From: [REDACTED]
Sent: 17 January 2018 10:58
To: Planning.Responses
Subject: RE: Please find attached amendment on planning application Ref: BN/28/17/RES

APPLICATION NO: BN/28/17/RES

Site Address: Land R/O Lillies Yapton Road Barnham PO22 0AY

Description of Works: Approval of reserved matters following outline consent BN/32/15/OUT relating to appearance, landscaping, layout & scale for erection of 38 No. dwellings including open space, landscaping & new access

APPENDIX C

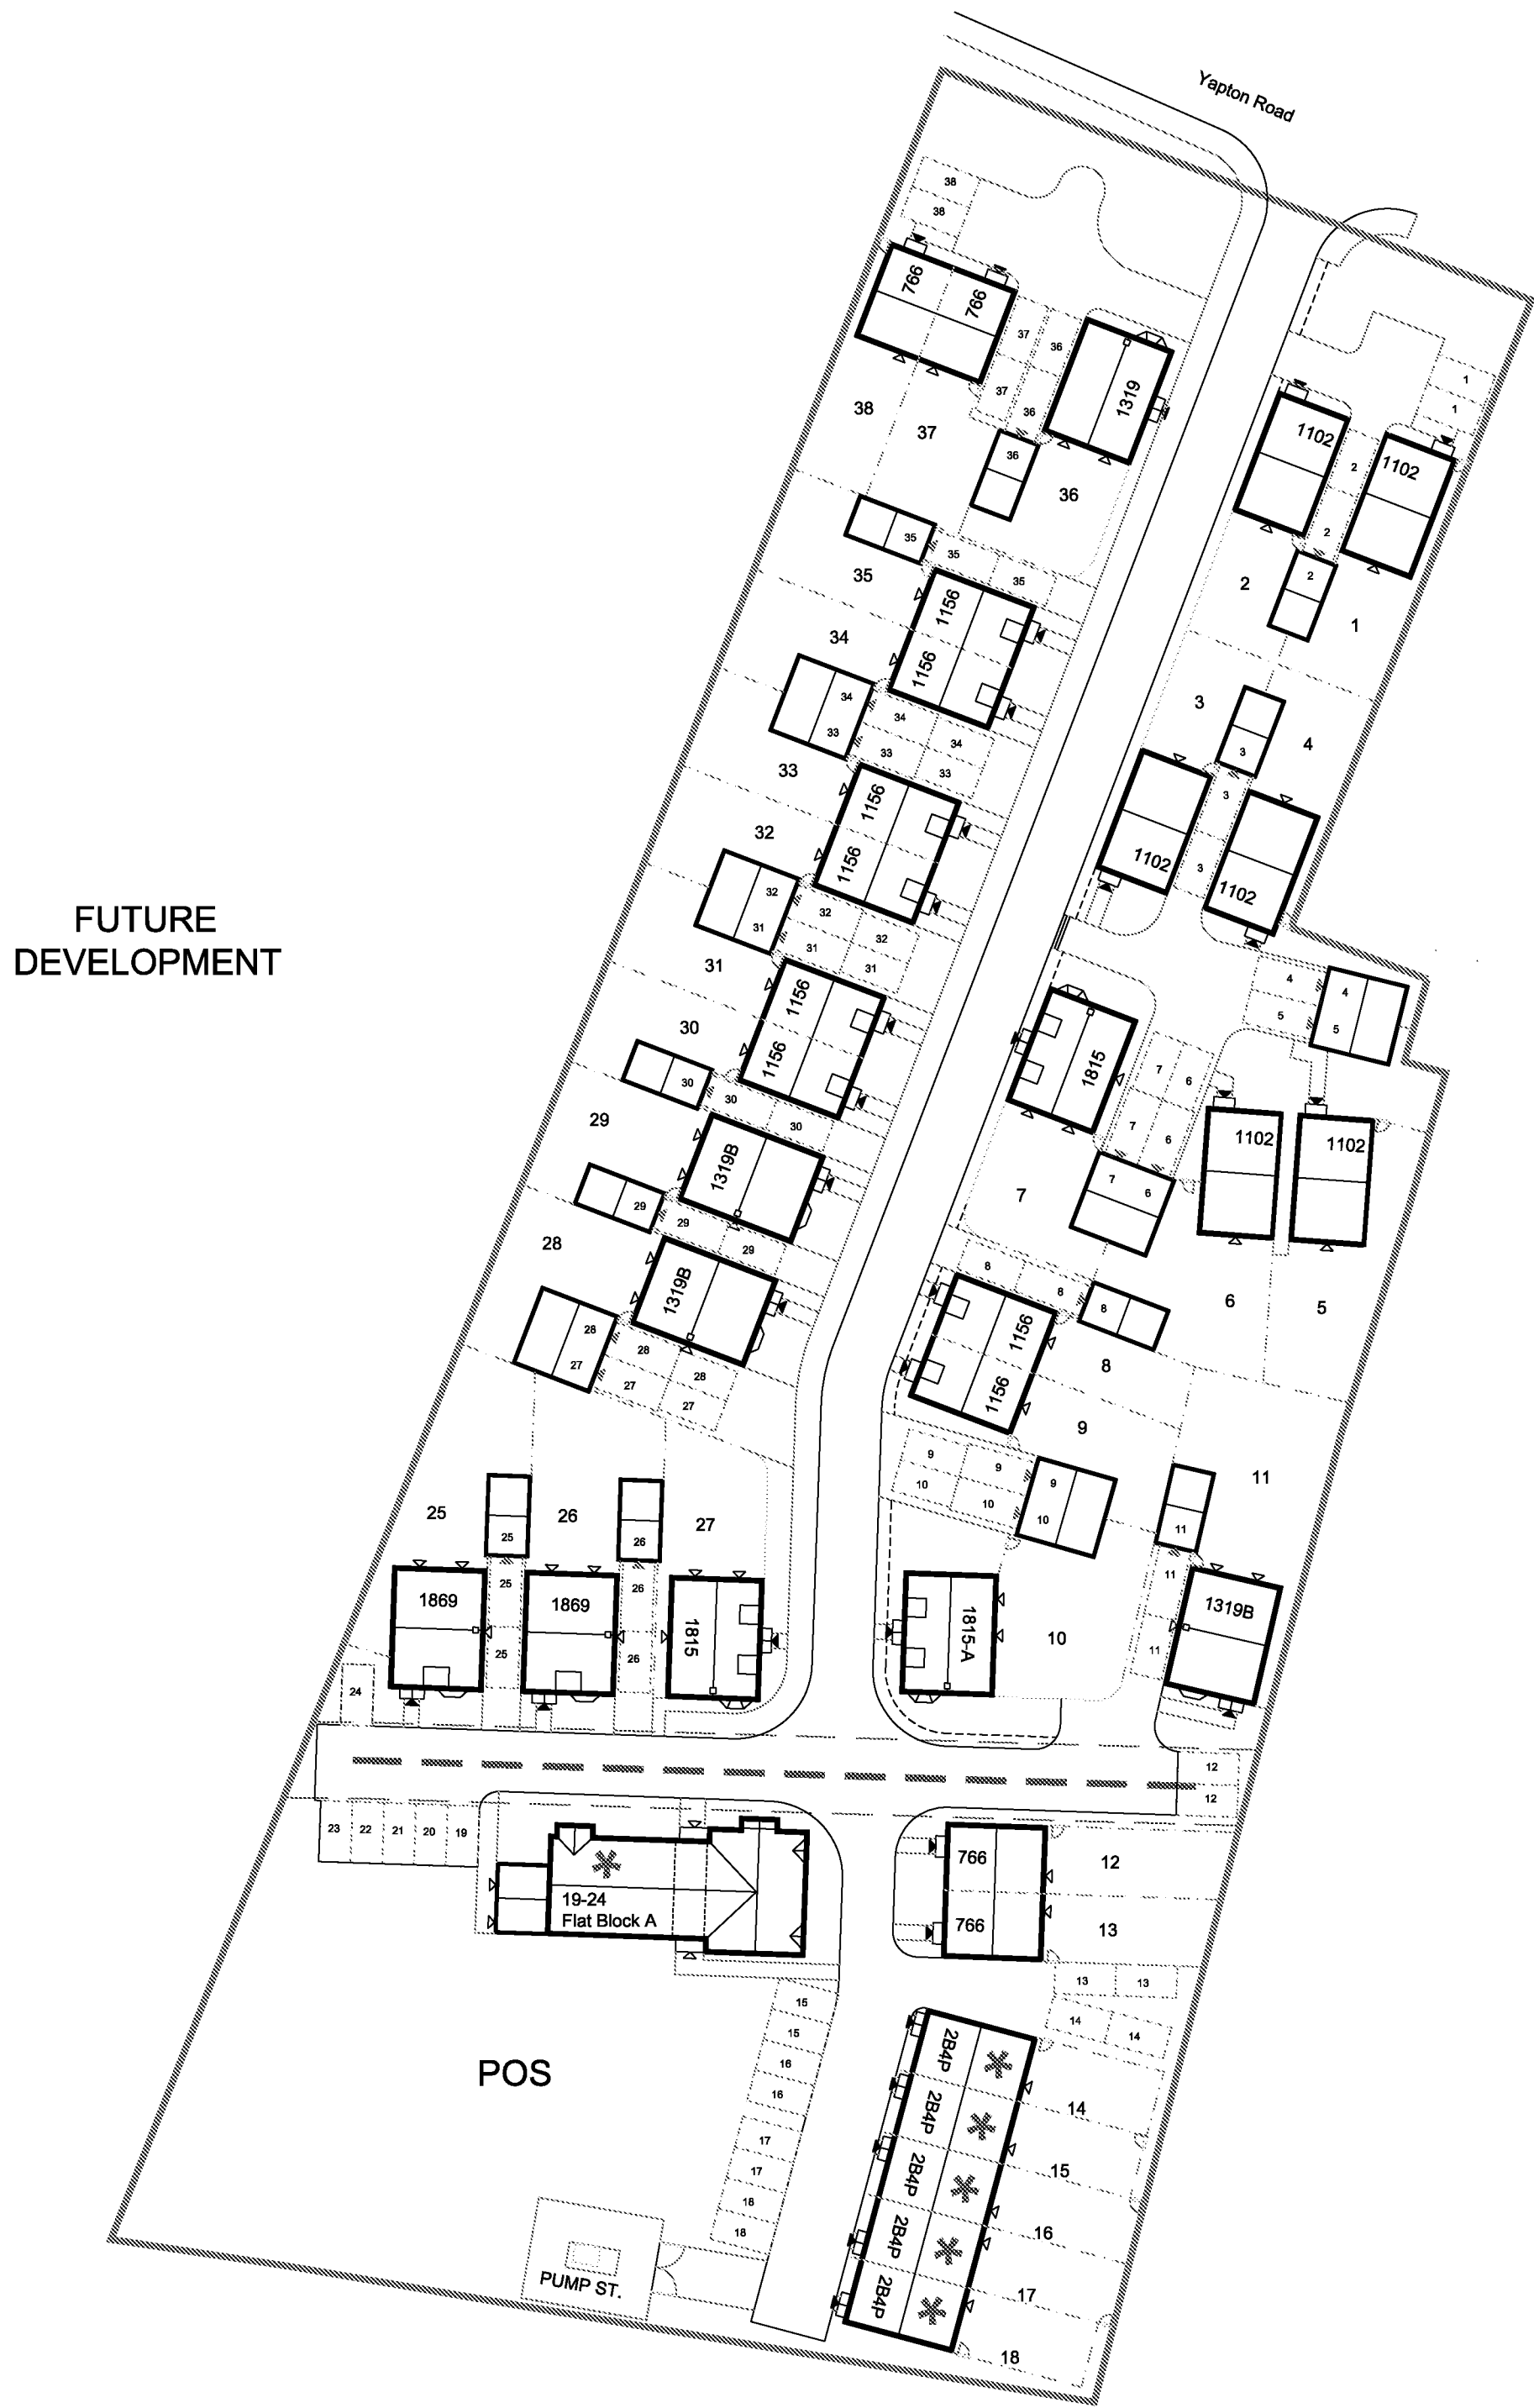
The plans as submitted still appear to show no connection to the land known as Angel's Nursery which was agreed in the original planning application and the Council feel that that this should be reinstated to enable residents to safely access the local amenities provided at Murrell's Field and Barnham Community Hall.

APPENDIX D

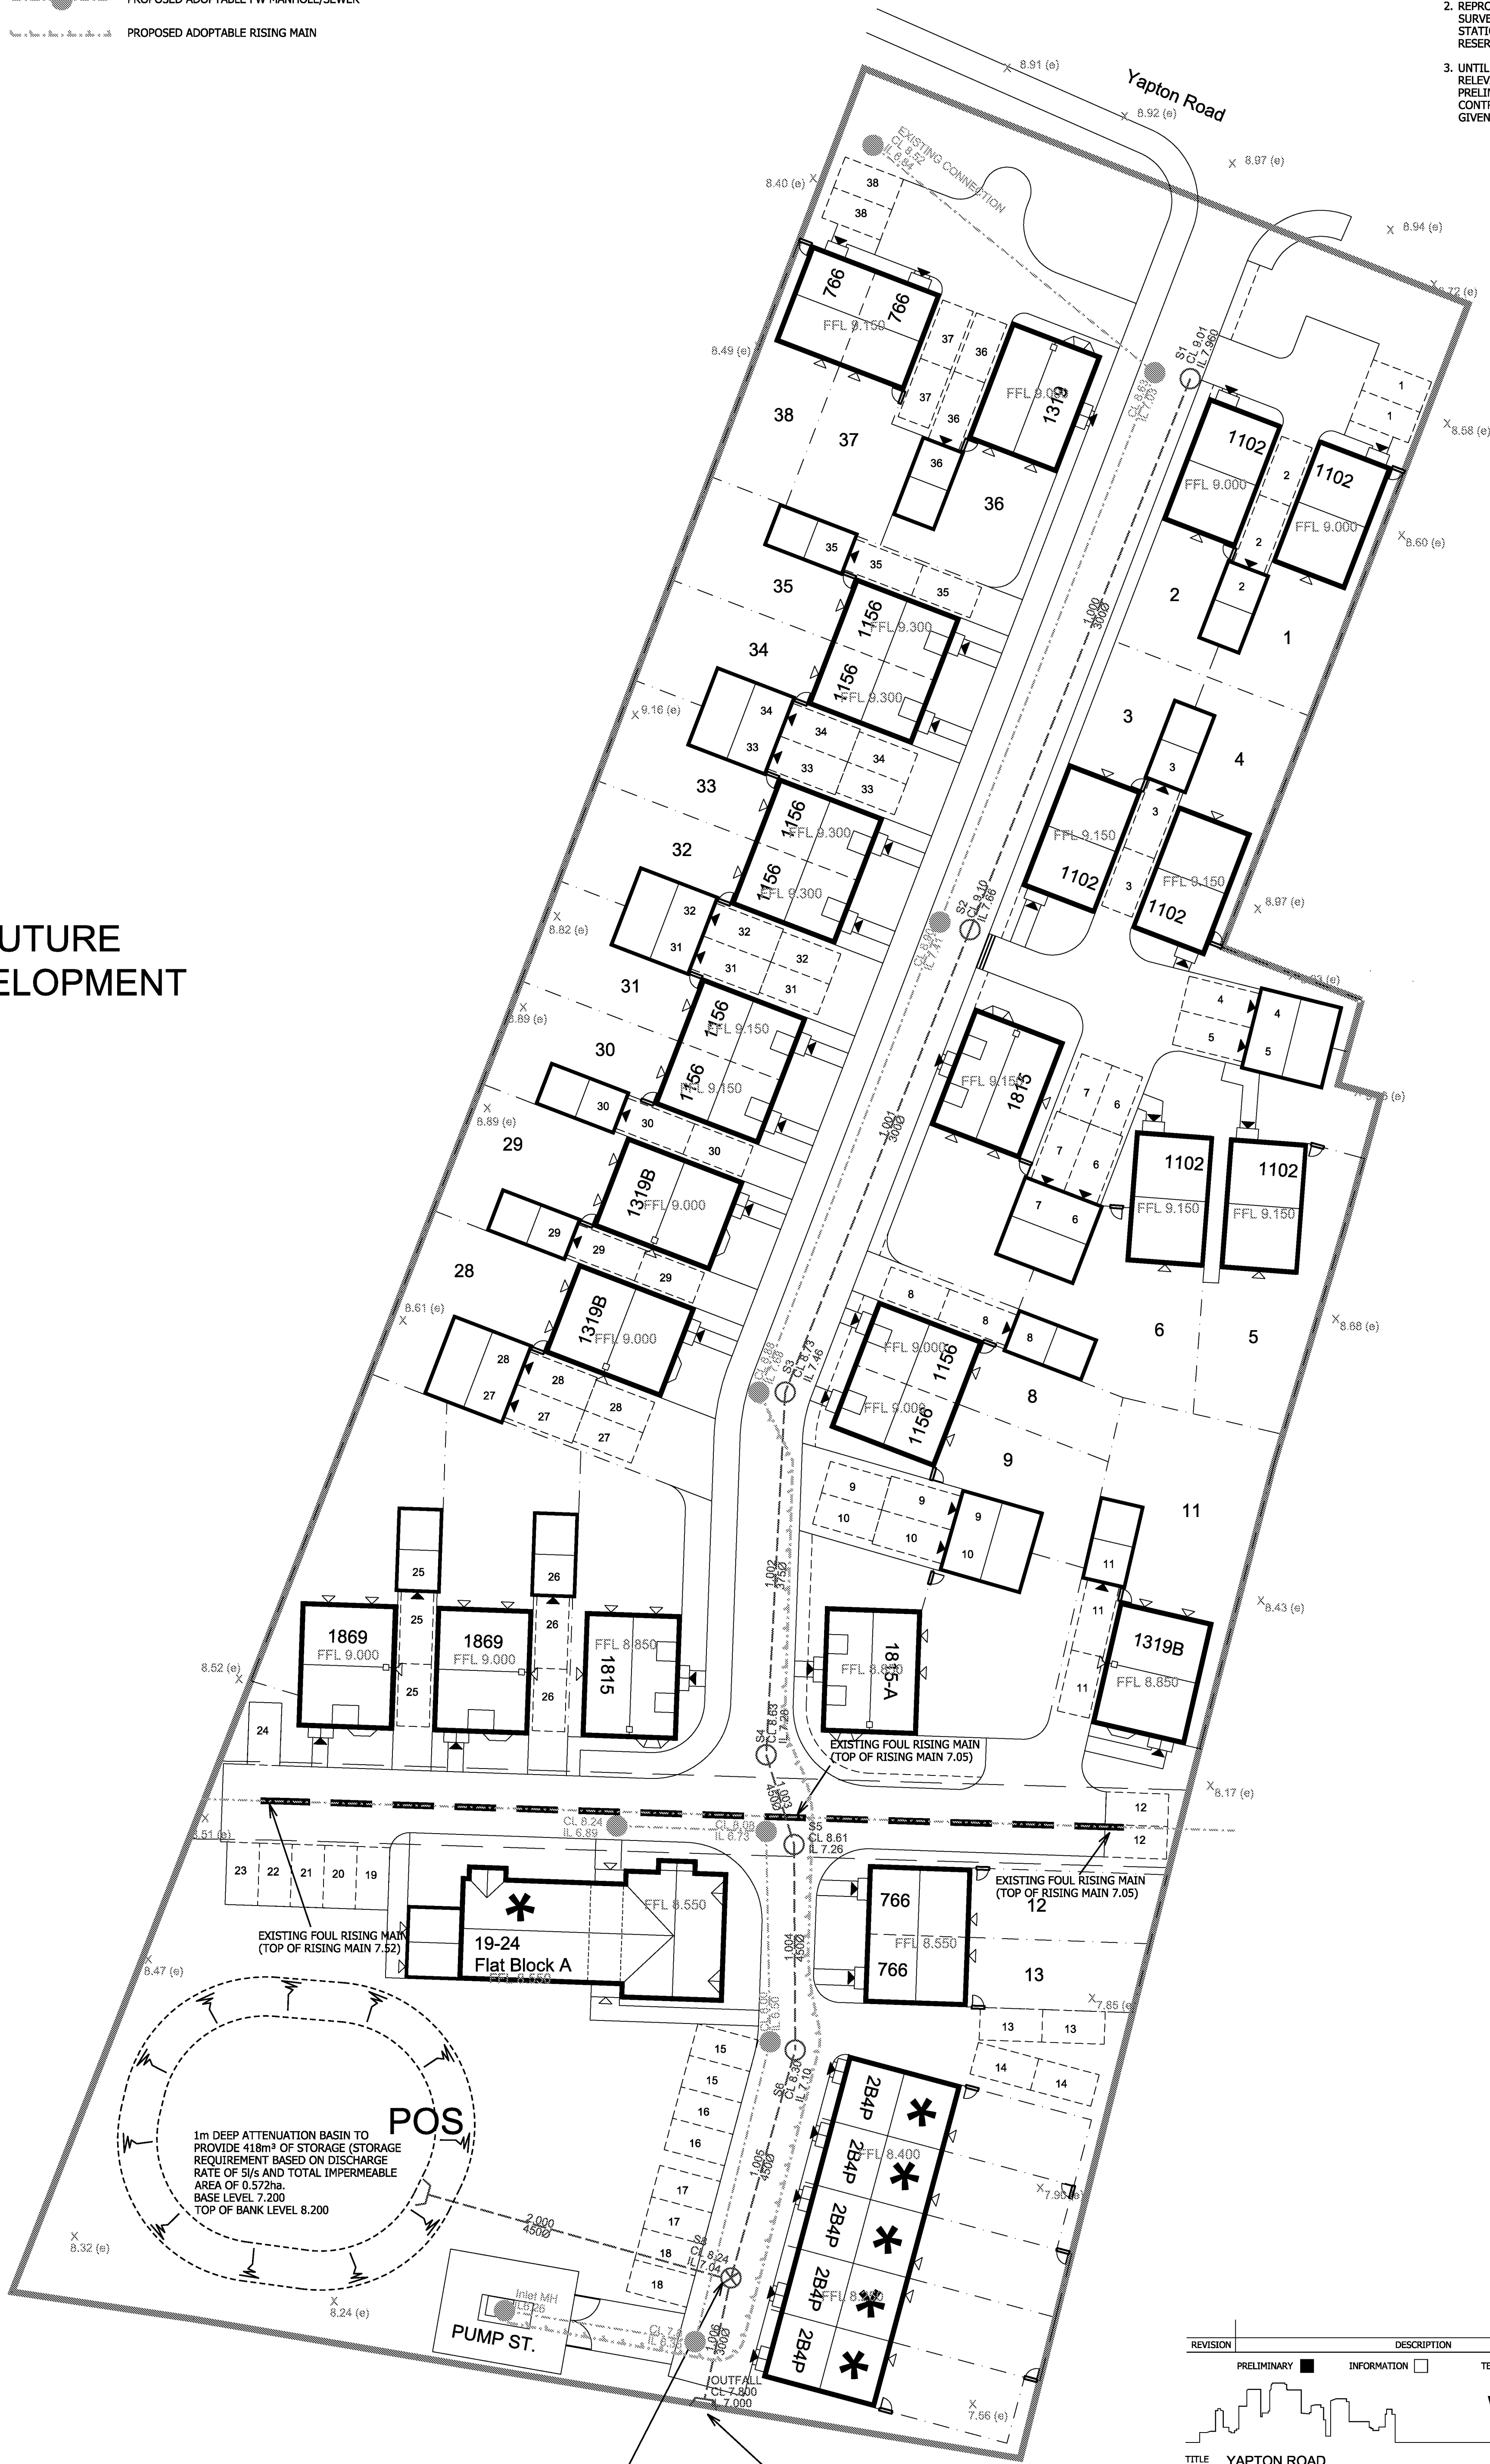
The Council has looked at the drainage document in particular and still has major concerns in respect of the inclusion of a SuDs system for dealing with surface water and the amount of water that will be discharged into the watercourse at the southern end of the site into an area that already has flooding problems in severe weather conditions. The Barnham and Eastergate Neighbourhood Plan Policy ES1 Flooding, drainage and new development relates. The Council has also noted that the ADC drainage experts has also commented on this issue. The Council would therefore wish to see the ADC's drainage experts suggestions incorporated into the scheme and hope that ADC will not allow the development to commence until they are satisfied that the risk of flooding through this watercourse is negligible.
